# CITY OF ALBUQUERQUE

August 31, 2016

**Re:** East Gateway Dwelling Units  
**13400 Wenonah Dr NE**  
**Traffic Circulation Layout**  
Architect's Stamp 07-13-16 (L22D033A1)

SHEET TCL 1.0

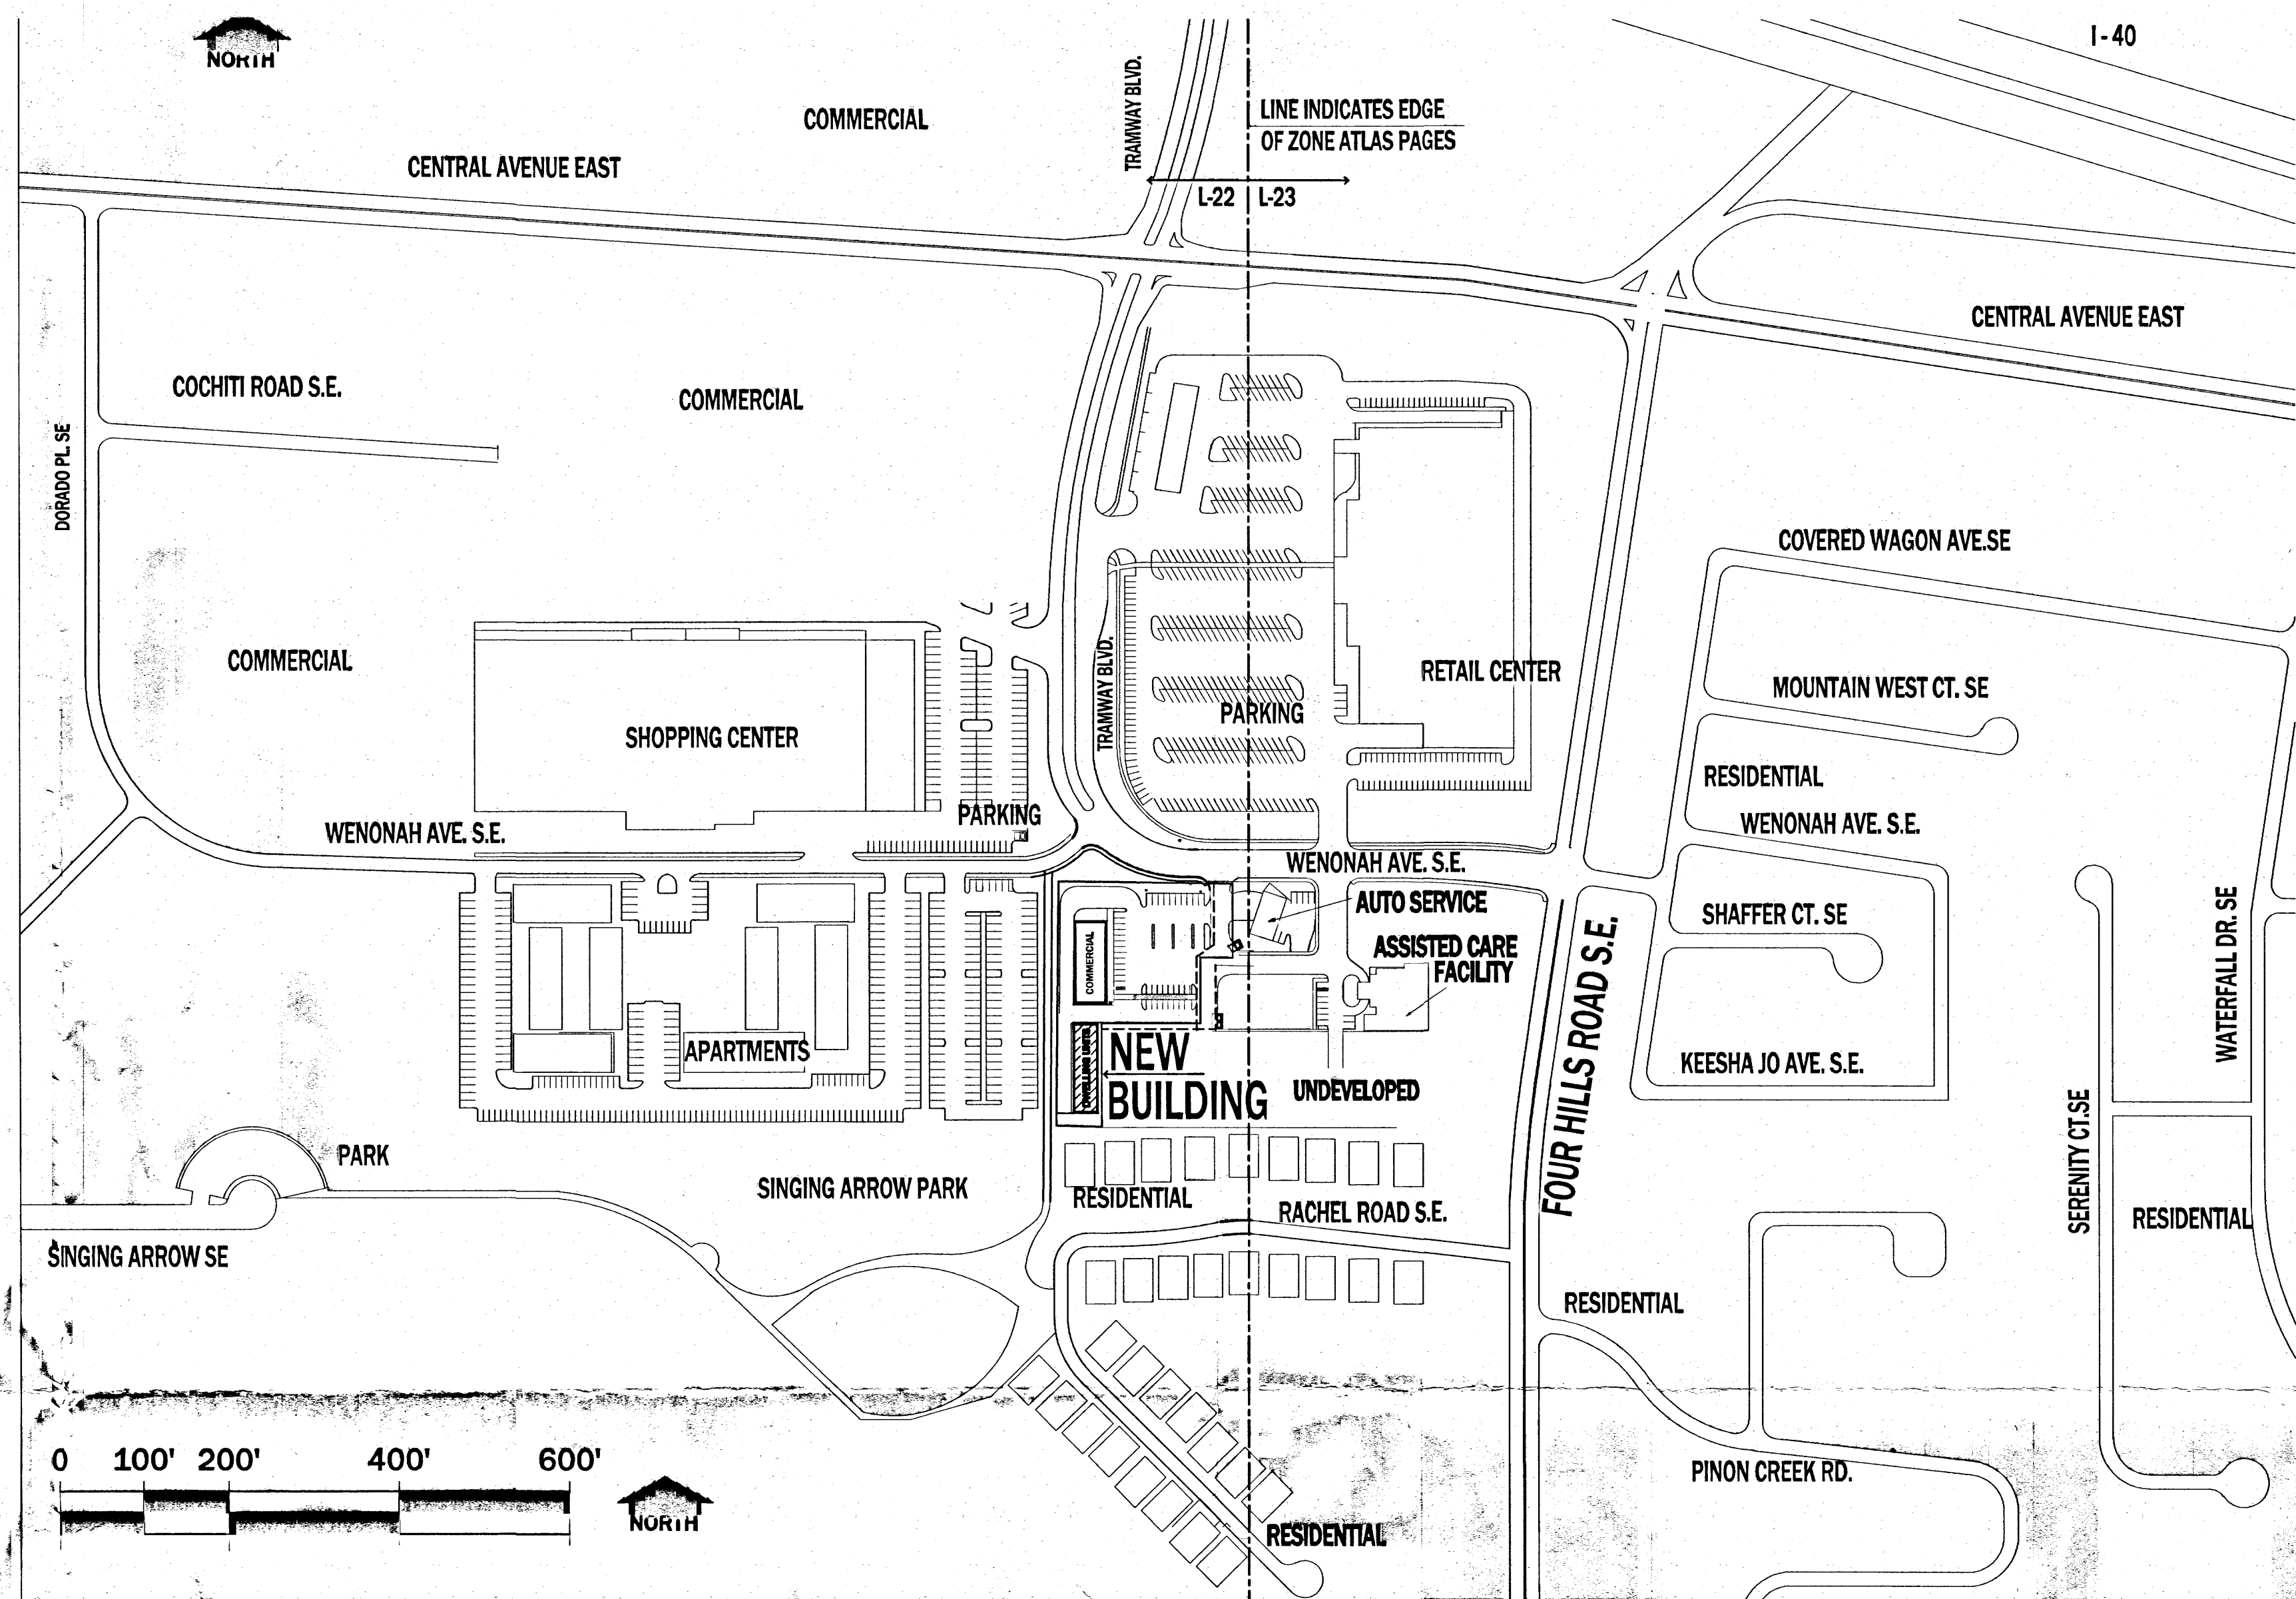
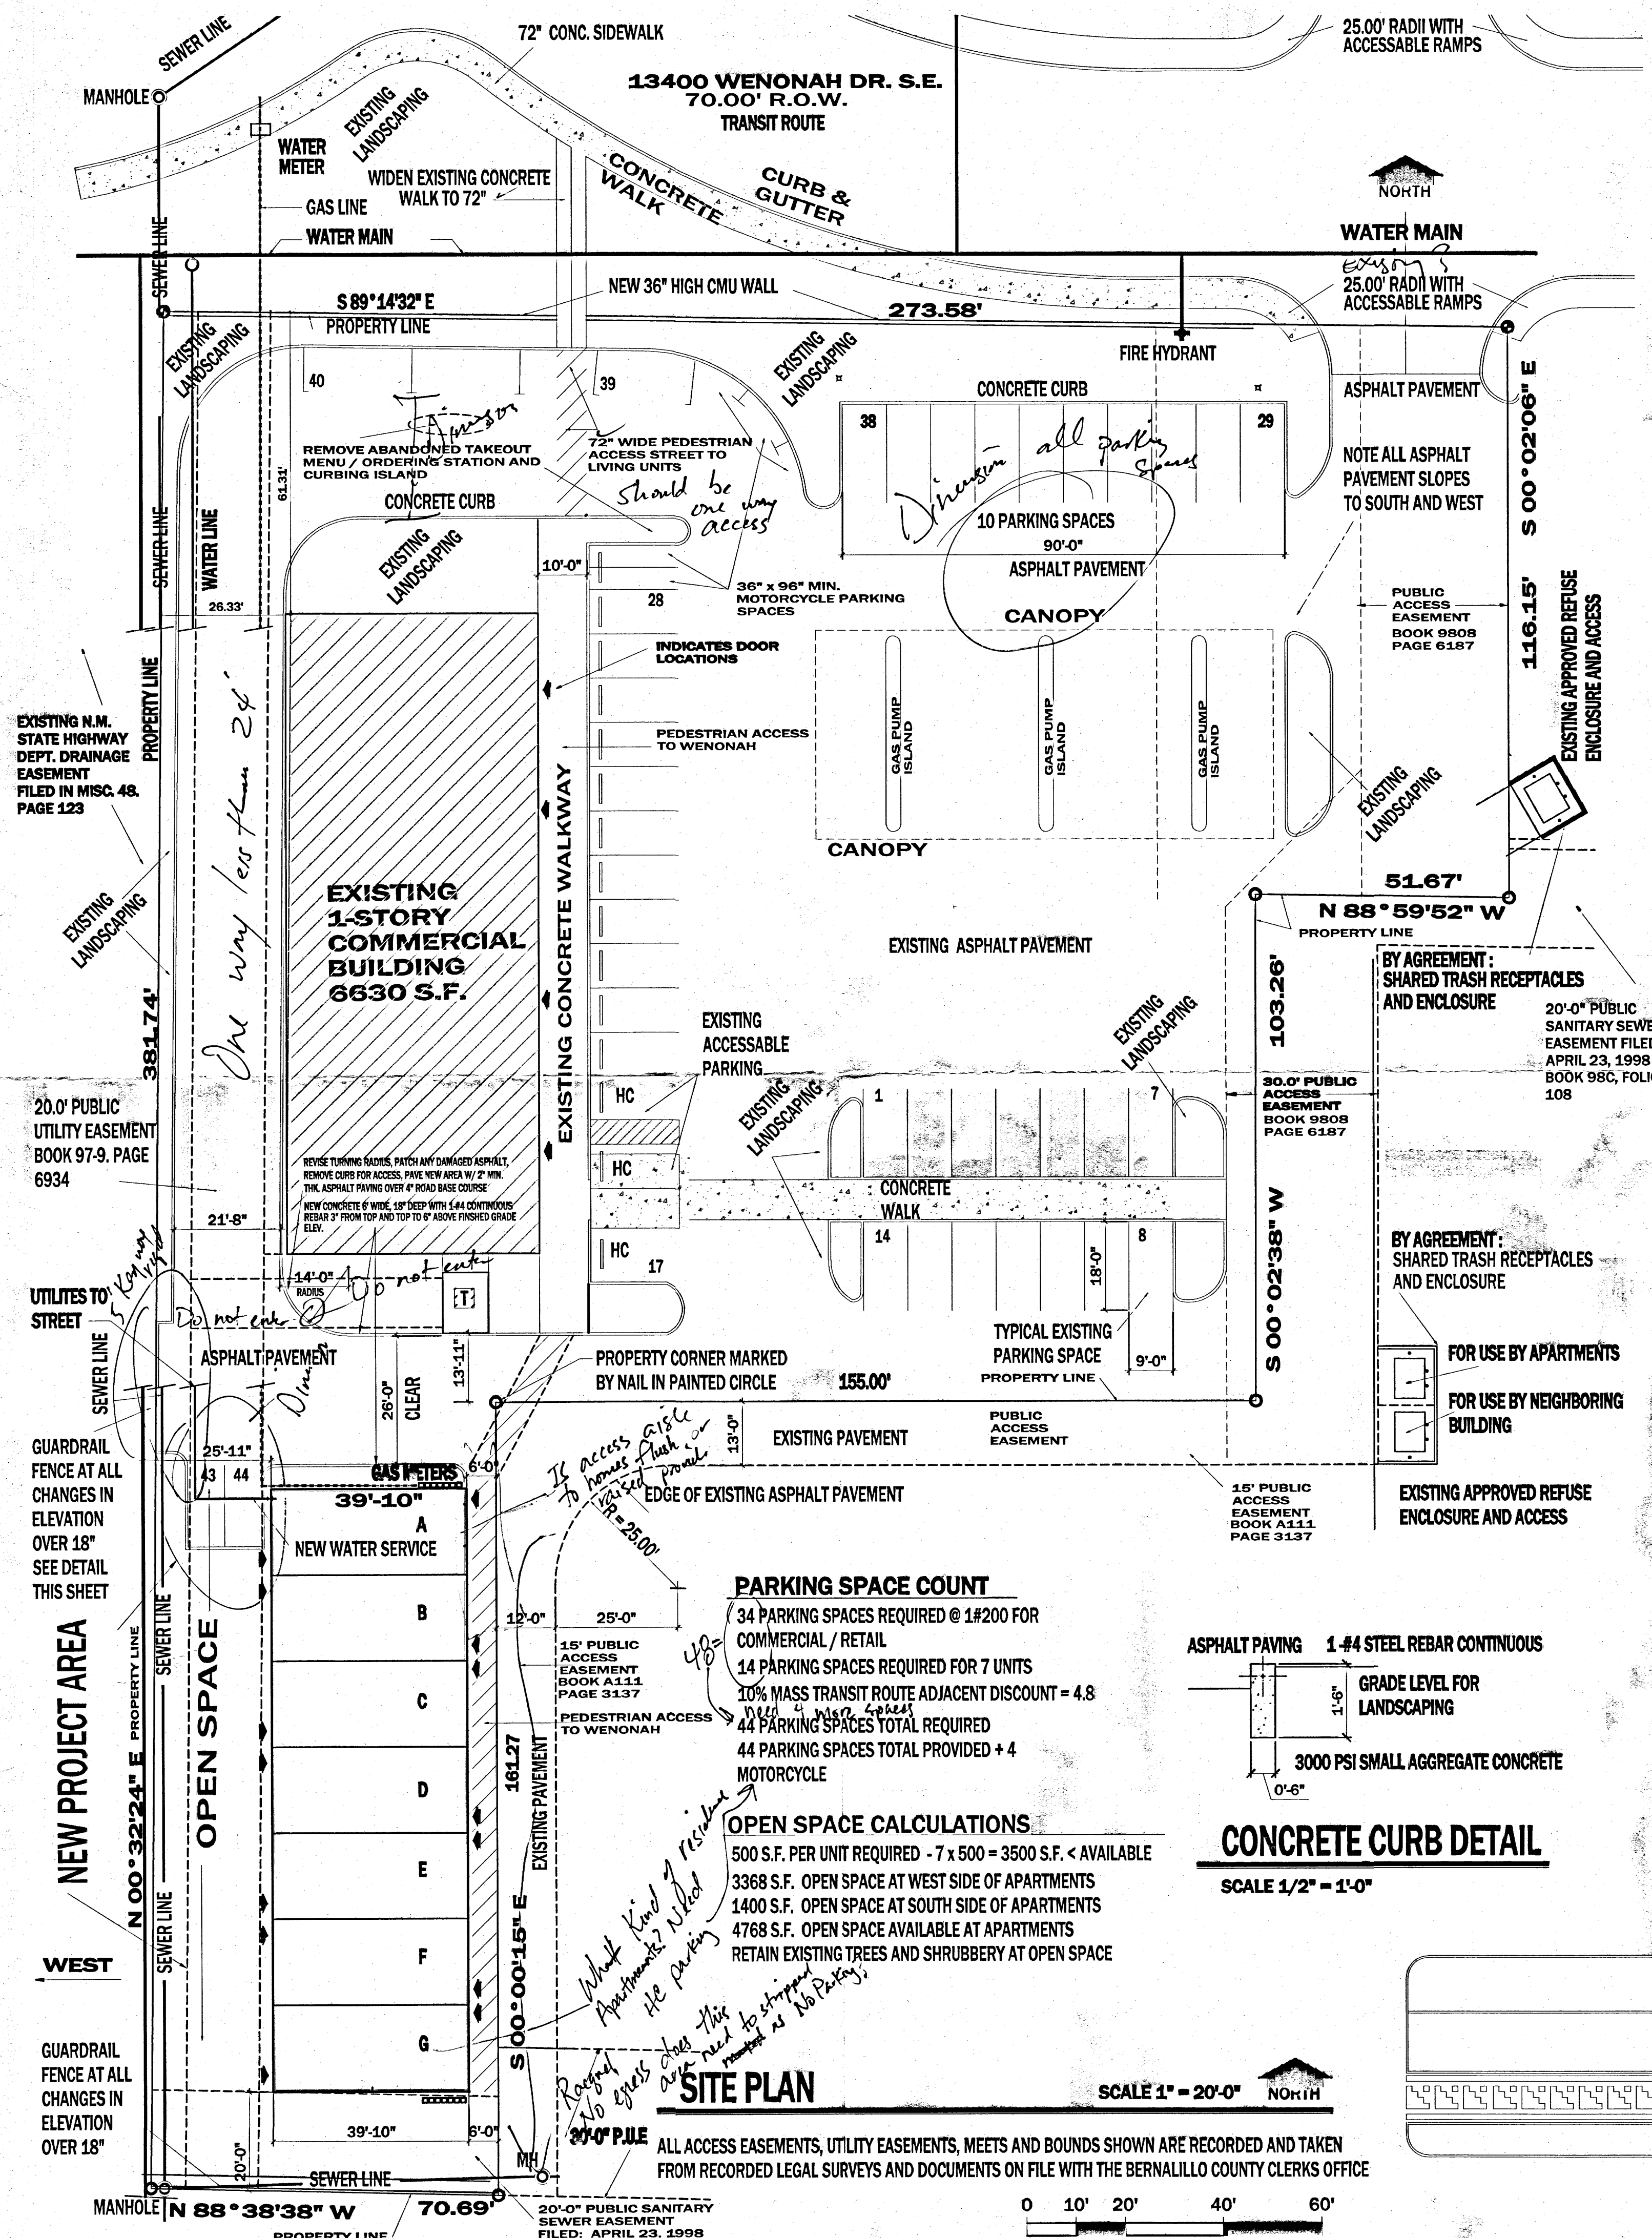
1. The number of parking spaces provided does not match the total required. Please provide number of ADA, motorcycle and bicycle parking required and provided for this site.

2. Identify the right of way width, medians, curb cuts, and street widths on Wenonah Ave.
3. Please list the width and length for all existing and proposed parking spaces. Some dimensions are not shown.

4. Motorcycle parking spaces must be visible to the entrance of the building.
5. A bicycle rack must be provided for the dwelling units.
6. The handicap accessible spaces must be a minimum of 8.5 ft. in width.

7. The handicap accessible spaces must include an access aisle. Van accessible aisles should be 8ft wide; all others should be 5ft wide.
8. The ADA accessible parking sign must have the required language per 66-7-352.4C NMSA 1978 **"Violators Are Subject to a Fine and/or Towing."** Please call out detail and location of HC signs.

9. The ADA access aisles shall have the words **"NO PARKING"** in capital letters, each of which shall be at least one foot high and at least two inches wide, placed at the rear of the parking space so as to be close to where an adjacent vehicle's rear tire would be placed. (66-1-4.1.B NMSA 1978)

10. Provide detail including dimensions for pedestrian and vehicular access to the dwelling units.
11. A 5 ft. keyway is required for dead-end parking aisles.

12. Provide a min 6" or max 8" high concrete barrier curb or other acceptable barrier between landscaping and parking areas and/or drive aisles. Please call out detail and location of barrier curb.

13. Dimension the drive aisle on the north side of the existing building from the perpendicular parking spaces to the concrete curb.
14. All drive aisle less than 24' may only be used at one-way access.

15. One-way vehicular paths require pavement directional signage and a posted **"Do Not Enter"** sign at the point of egress. Please show detail and location of posted signs.

16. Show the clear sight triangle and add the following note to the plan:  
"Landscaping and signage will not interfere with clear sight requirements. Therefore, signs, walls, trees, and shrubbery between 3 and 8 feet tall (as measured from the gutter pan) will not be acceptable in the clear sight triangle.

17. Please specify the City Standard Drawing Number when applicable.
18. Please include a copy of your shared access agreement with the adjacent property owner.

19. Add a note stating "All broken or cracked sidewalk must be replaced with sidewalk and curb & gutter." A build note must be provided referring to the appropriate City Standard drawing.
